DOC17/599447-01
SSD 8647

SSD 8647 – HORNSBY HOSPITAL RE-DEVELOPMENT – ENVIRONMENTAL IMPACT STATEMENT (EIS)

HORNSBY HOSPITAL RE-DEVELOPMENT STAGE 2 EIS

Figure 3 – Recommended Screen Around Existing Generator

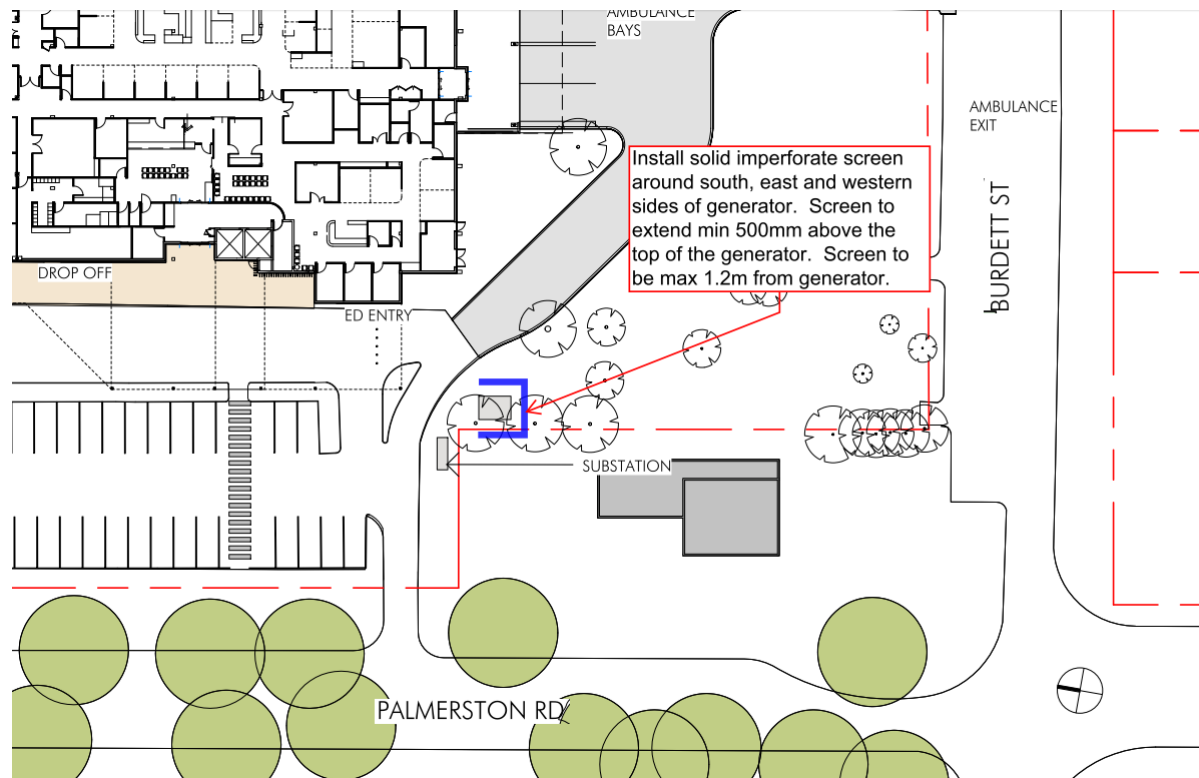
EIS section 6.5.2 under the heading 'Mechanical plant' and section 6.3.3 to EIS Appendix Q *Acoustic Assessment* indicate that details of mechanical services, plant and equipment are yet to be determined. However, the EIS does indicate the location of the existing back-up generator (proposed to also serve stage 2) and roof top plant rooms.

- (b) ensure mechanical plant and equipment installed on the development site does not generate noise that –
 - (i) exceeds 5 dBA above the rating background noise level (day, evening and night) measured at the western boundary of the development site, and

- (ii) exhibits tonal or other annoying characteristics;
- (c) undertake compliance noise monitoring during commissioning of stage 2 to confirm that the operation of mechanical plant and equipment, including emergency back-up generators, does not emit noise in excess of the criteria referred to in preceding paragraph (b);

APPENDIX 1 – NOISE MONITORING ALONG BURDETT STREET

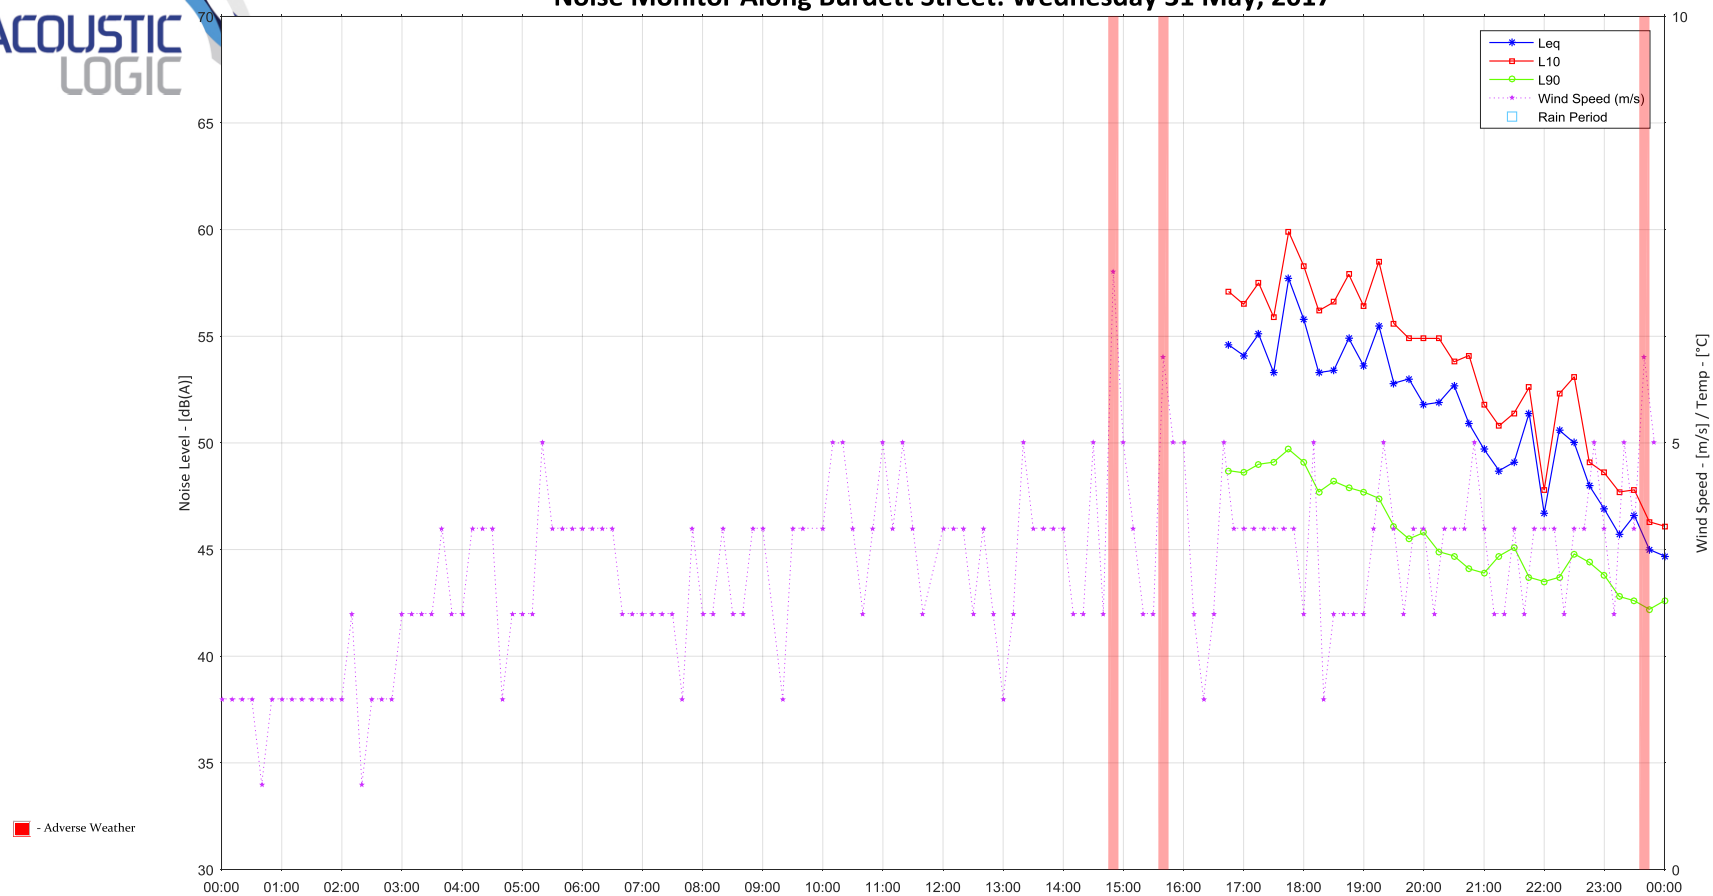
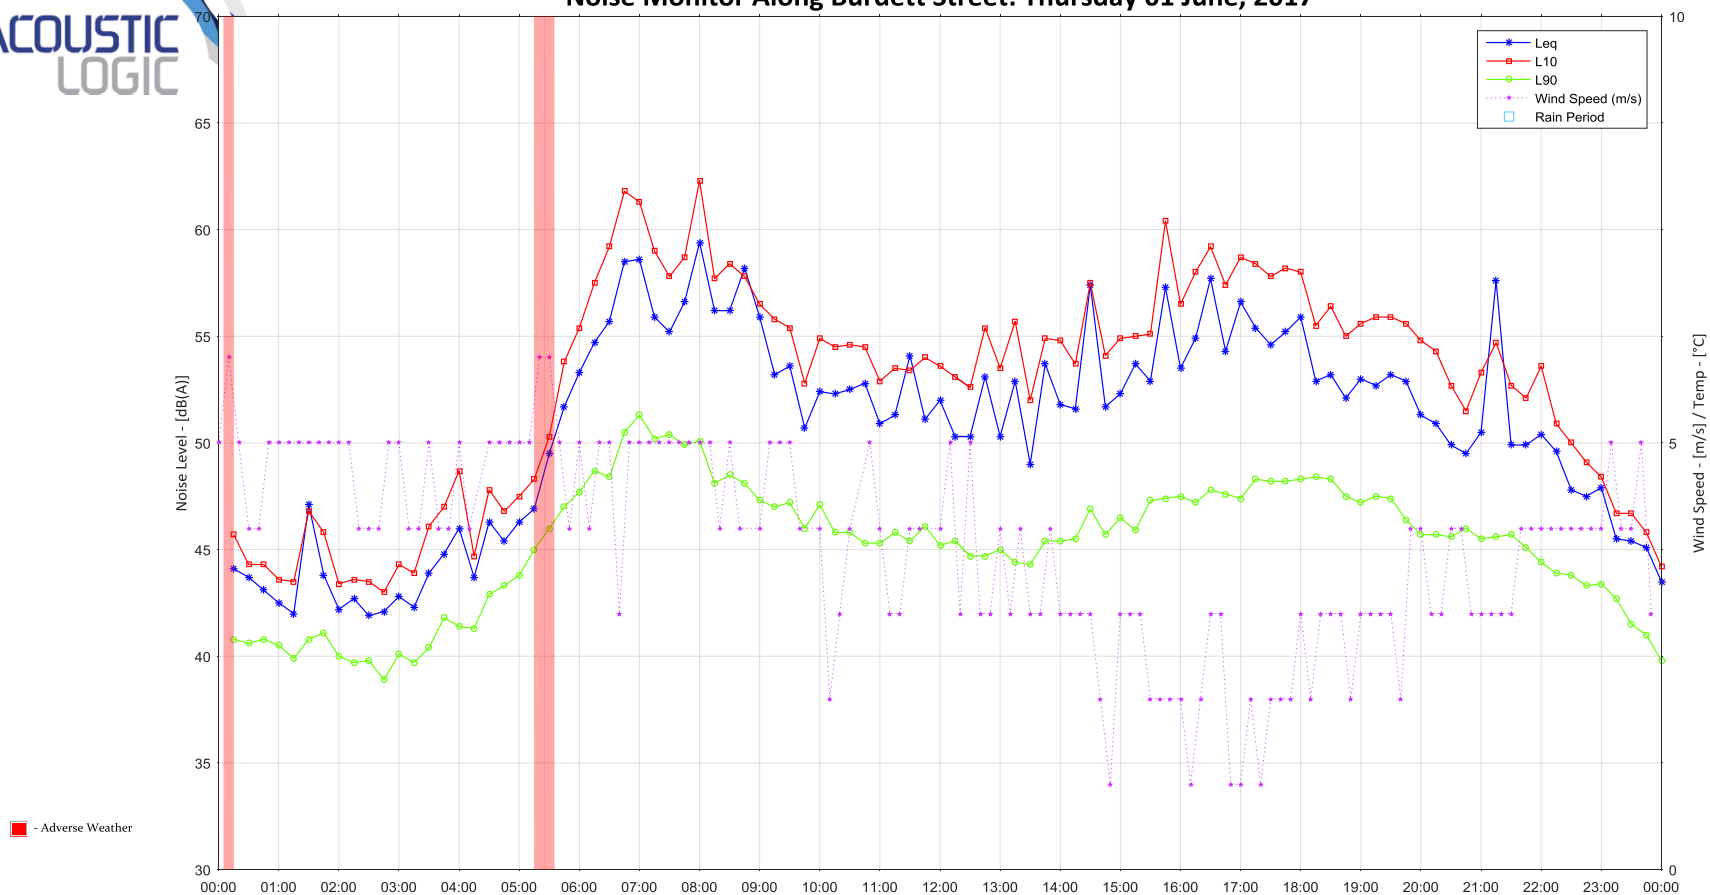
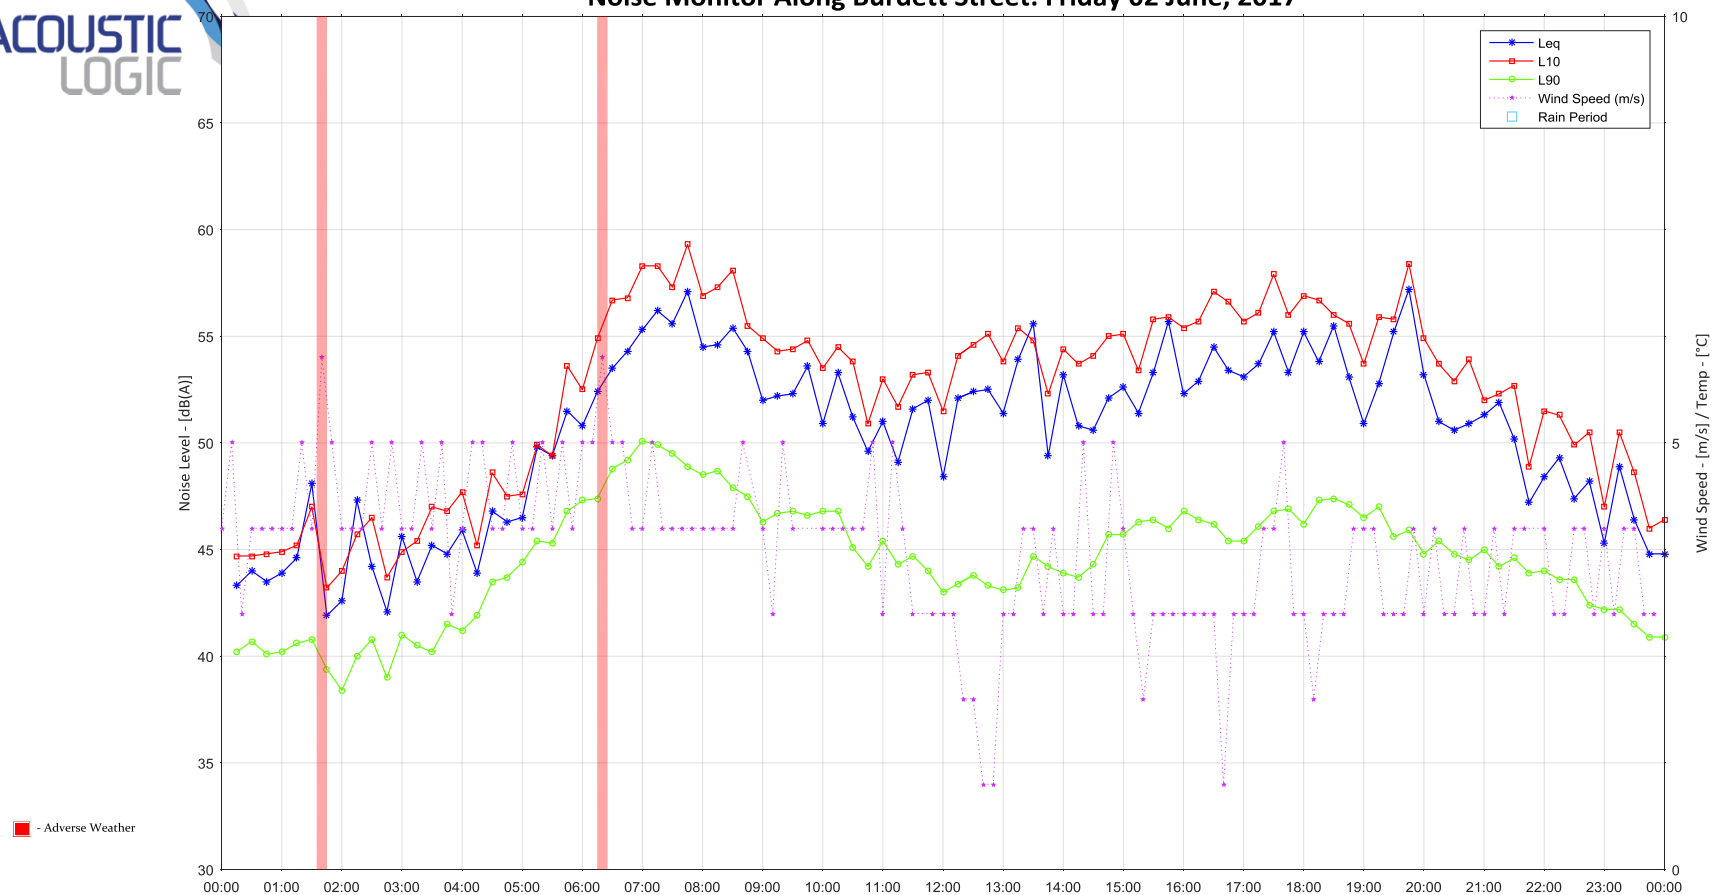
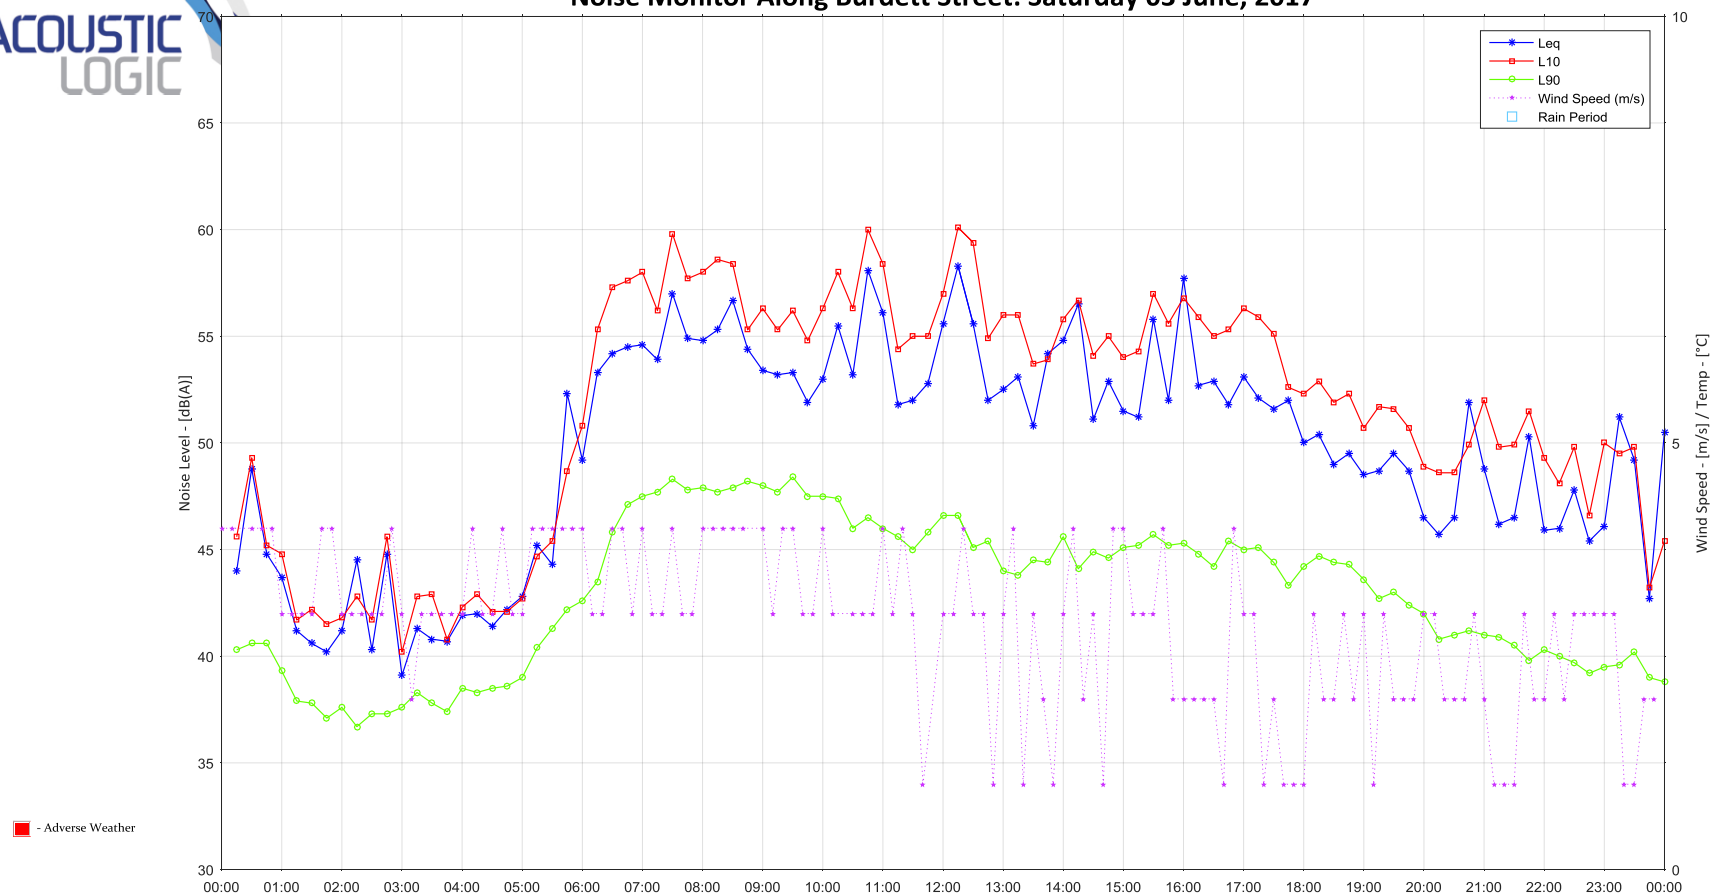
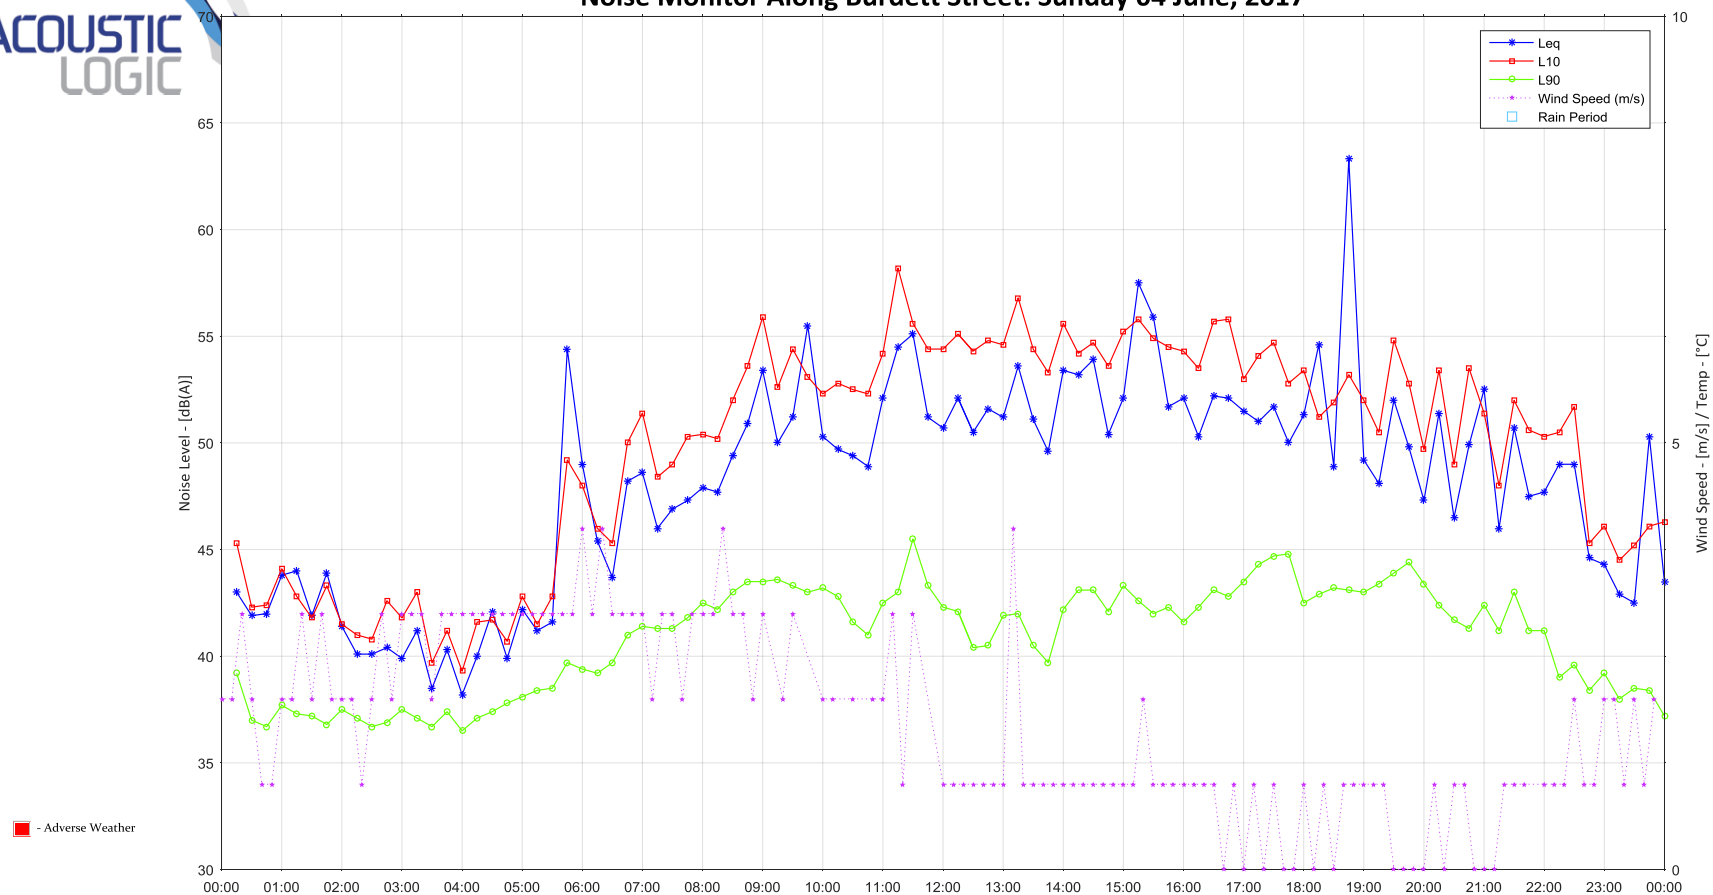
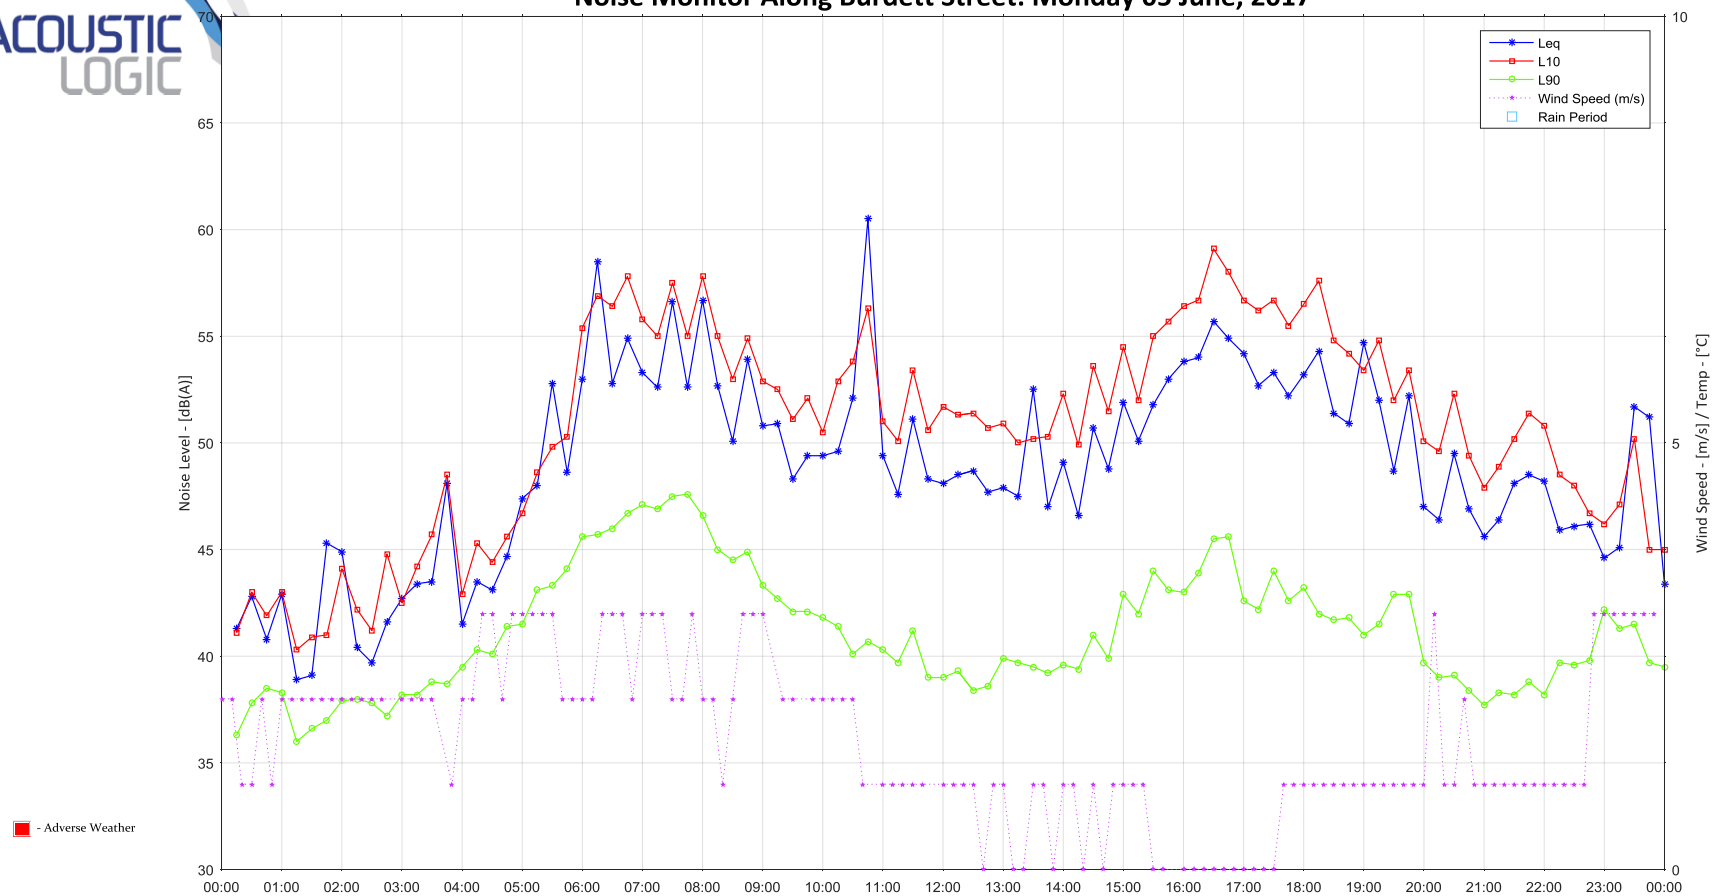
Section 4.1 to Appendix Q states that "[o]n review of the monitoring data, the measured L_{90} noise levels during high wind speed days generally do not increase background noise level significantly". The EPA considers the foregoing statement to be inaccurate for the graphs presented of the Burnett Street data, which show exactly the opposite for the evening of 6 June and all the data for 7 June.

- (a) the legends to some monitoring graphs appear to be misaligned (e.g. wind speed, rain period),

- (b) the legends to monitoring graphs includes a blue marker for 'rain period' and although rain was observed on several days during the various monitoring periods (i.e. 24 May to 7 June 2017), no rain periods are represented in the graphs, and
- (c) some of the monitoring graphs include sections of red highlight, but there is no red marker in the legend to those graphs to identify the meaning of those red highlighted periods, and
- (d) Appendix Q does not appear to identify when noise monitoring loggers were last laboratory calibrated which brings into question reliability of the recorded data.

- (a) the equivalent of a week's worth of valid data, measured at the potentially most affected noise sensitive receiver locations in Burdett Street, Derby Street and Palmertson Road; and
- (b) the results of attended monitoring, graphical results of unattended monitoring with a complete and accurate legend together with a table of assessment background and daily ambient levels.
